J. SMITH STRUCTURAL ENGINEERING, PLLC
N.C. CERTIFICATE NUMBER P-2212

July 27, 2022

RE: Teralyn II – 32 Timber Rail Lane
I-joint repair over garage and rafter tiebacks

**S-2**  
**SECOND FLOOR FRAMING PLAN**

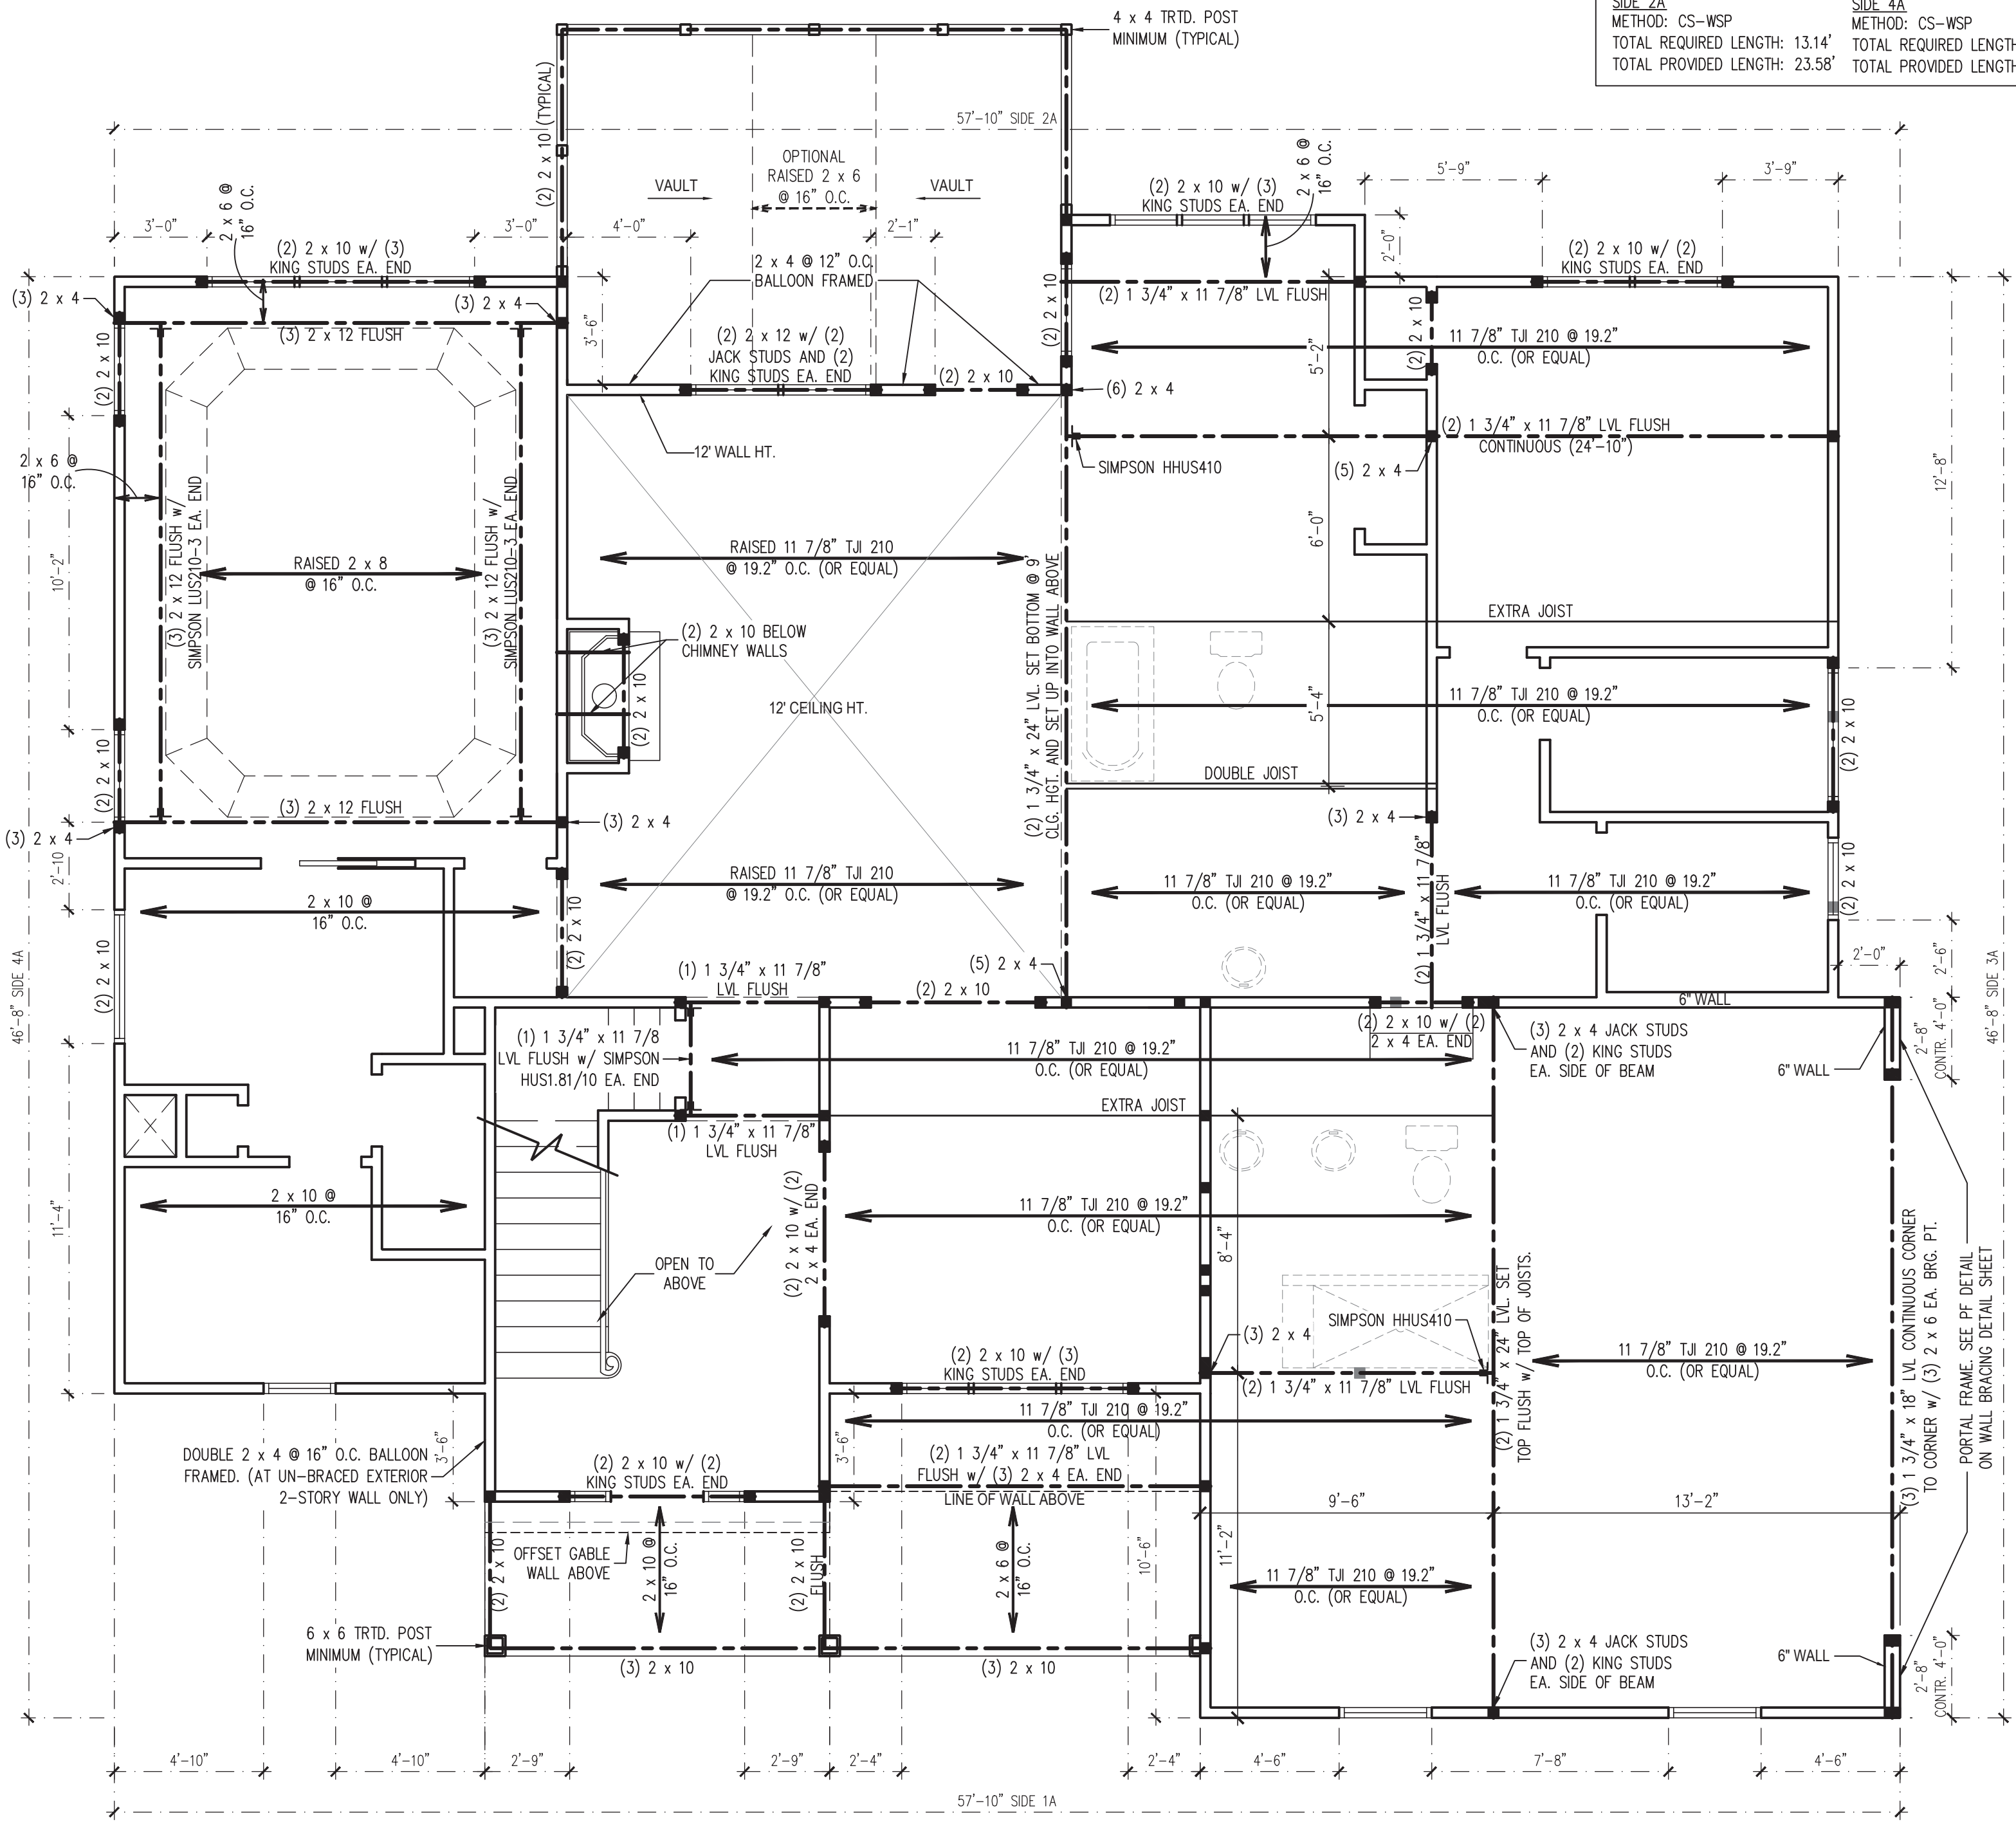
1. At the double I-joint below the bathroom wall, the top chord of (1) I-joint ply was notched for a plumbing line. To reinforce the damaged I-joint, (1) layer of $\frac{3}{4}$ " OSB x 4' long was installed against the I-joint web centered at the notch and secured with (2) rows of 10d nails @ 4" o.c.. A 4' long 2 x 4 scab was secured to the face of the top chord and centered at the notch. The 2 x 4 scab was secured to the top chord with (1) staggered row of 10d nails @ 4" o.c.. This reinforcement configuration is adequate to support all applied loads.
2. In lieu of H2.5A hurricane ties at each rafter bearing, 2 x 4 rafter tie backs were installed on every other rafter in various attic locations. This framing configuration is adequate to support all applied loads and no additional hurricane ties are required.
